Re: Planning Application 19/1031 and 1032

Address: Plots 1 and 2, 8 Hammond Drive Read BB12 7RE

Description: Proposed two-story dwelling house with integral garage, parking and drive access.

Plot 1
Site Layout & Sections

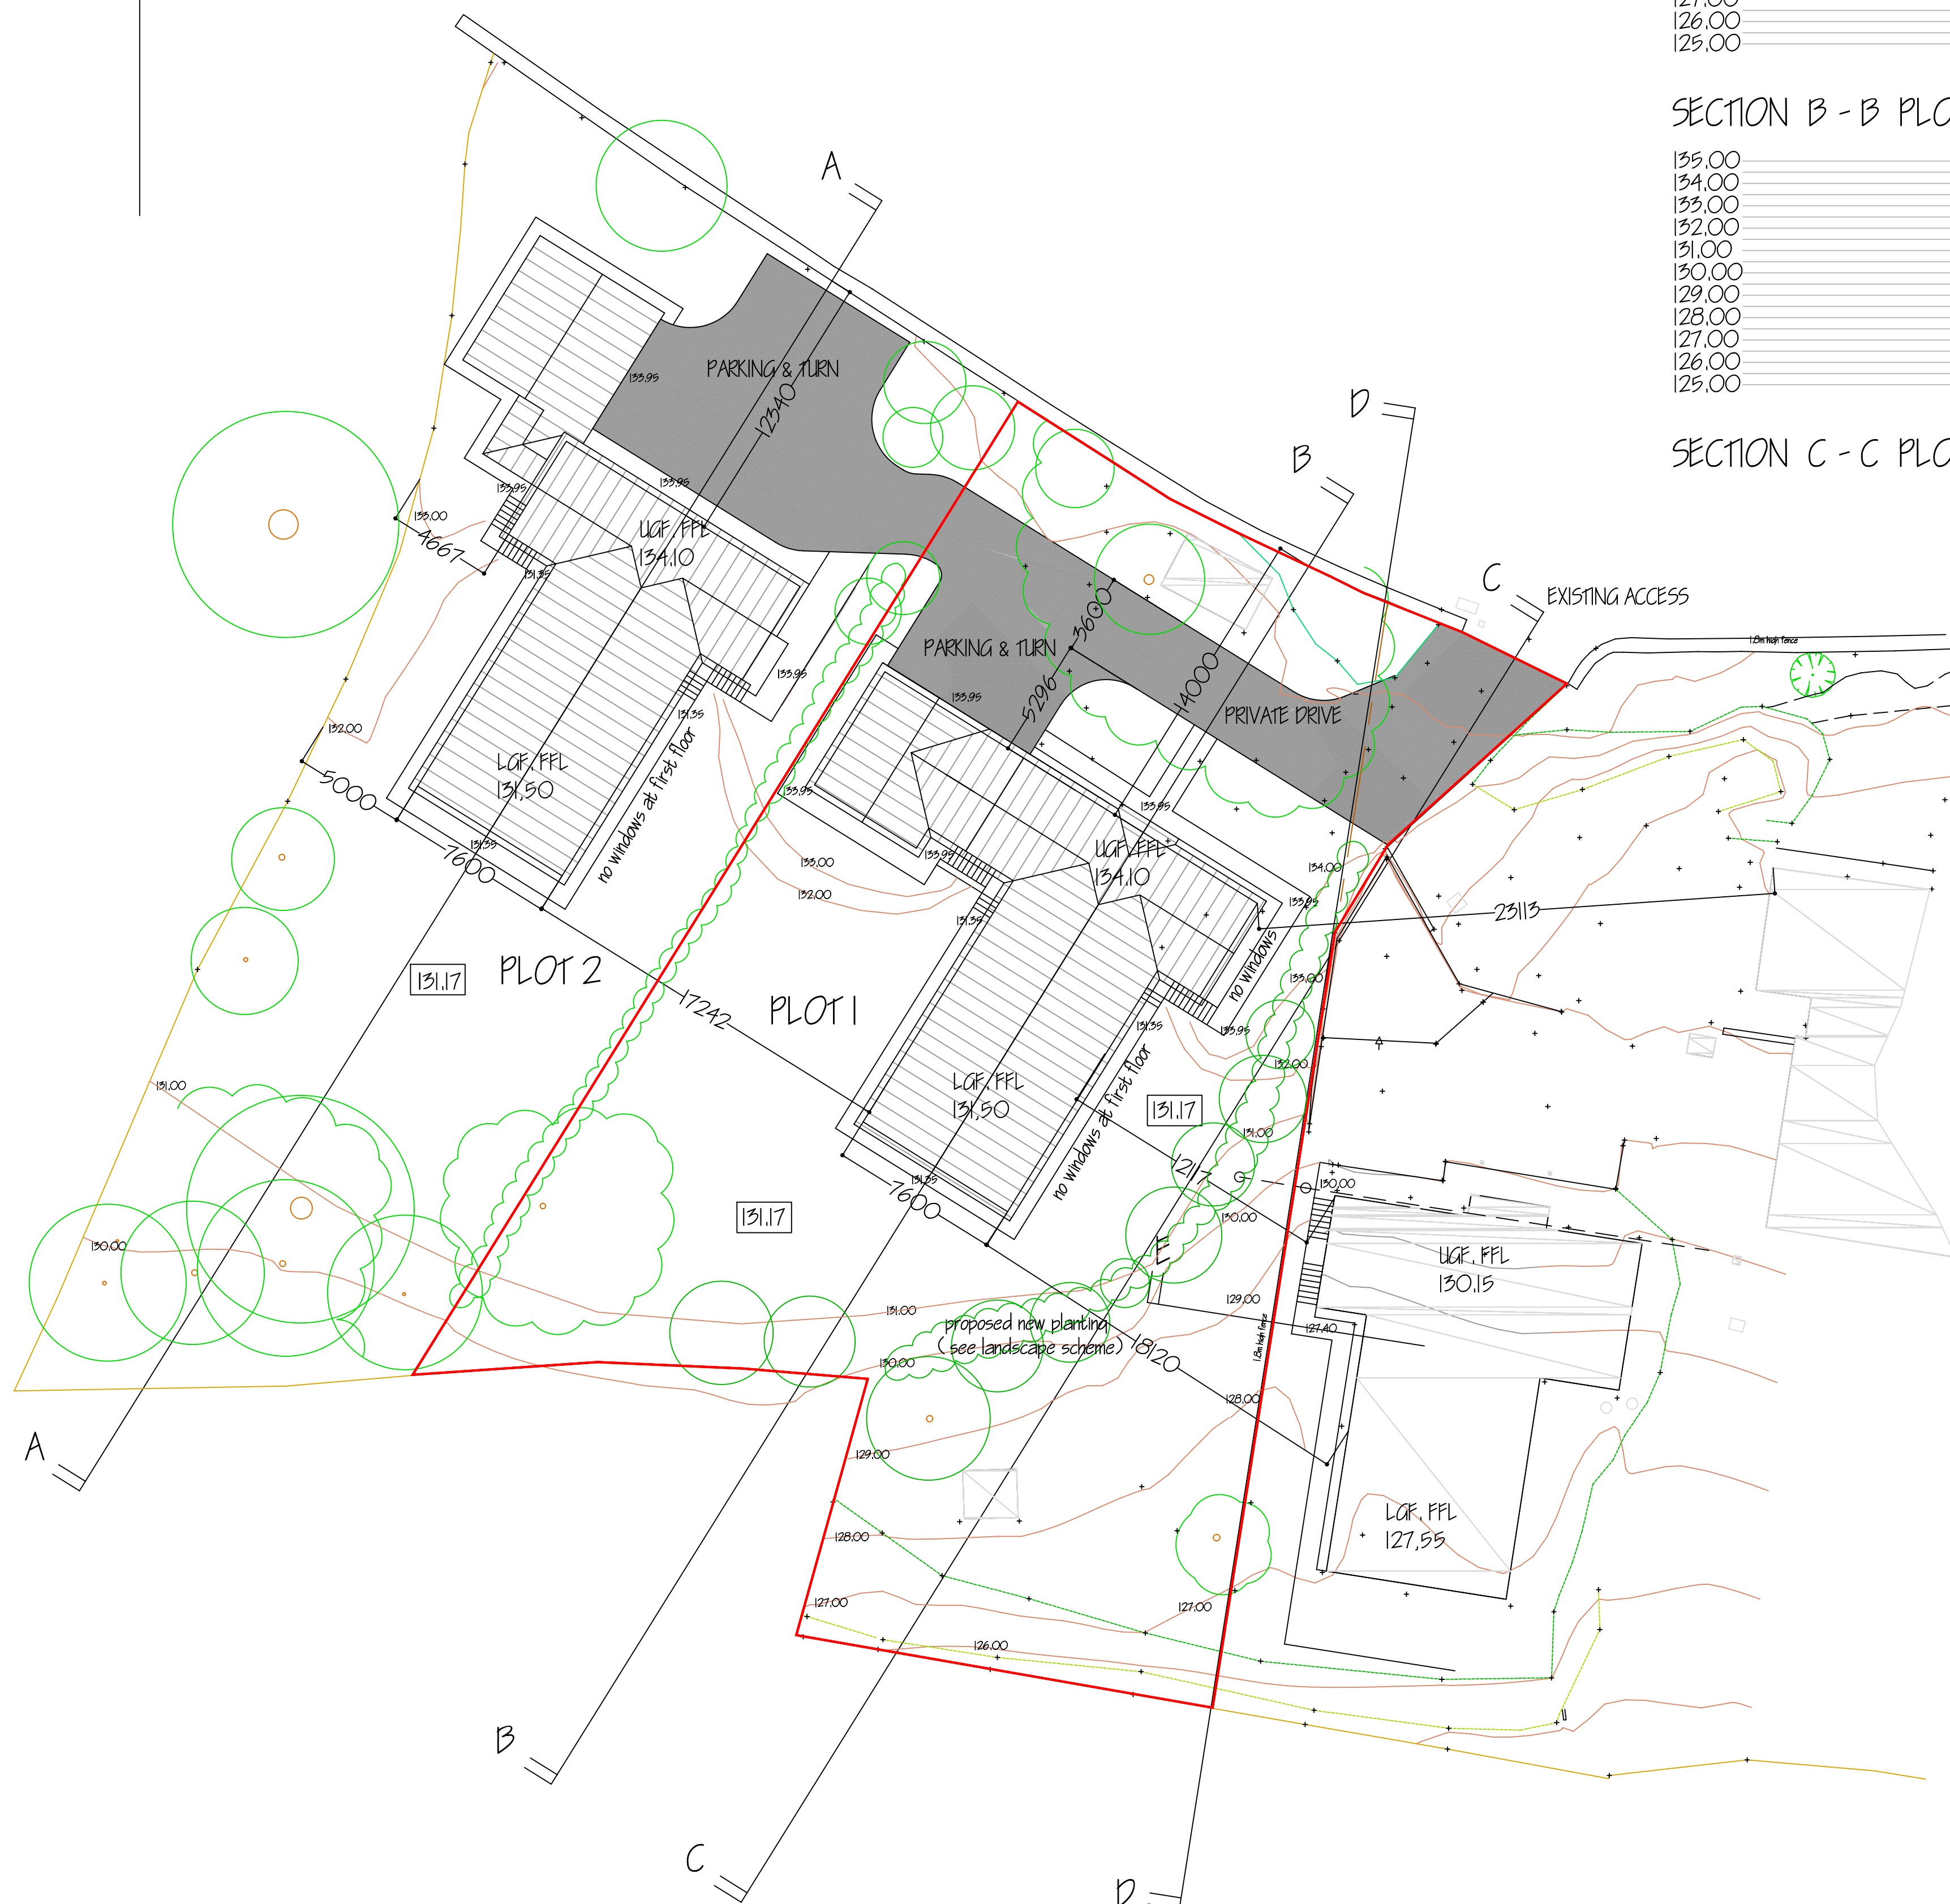
Whilst a further plan showing a widened drive has been provided, it has not been shown that this access will allow two vehicles to pass as they enter and exit the site. Although not shown on the plans provided it is apparent that the access will be used for 3 dwellings

In order to support the application we would still look for a plan with a swept path analysis to allow for 2 family cars, such as a Ford Mondeo to pass in the widened access. Although the access has been widened in line with what would be expected as a standard drive way the comparative narrowness of Hammond Drive may hinder the turning movements.

1. Before the access is used for vehicular purposes, that part of the access extending from the highway boundary for a minimum distance of 5m into the site shall be appropriately paved in tarmacadam, concrete, block pavements, or

other approved materials. **Reasons:** To prevent loose surface material from being carried on to the public highway thus causing a potential source of danger to other road users.
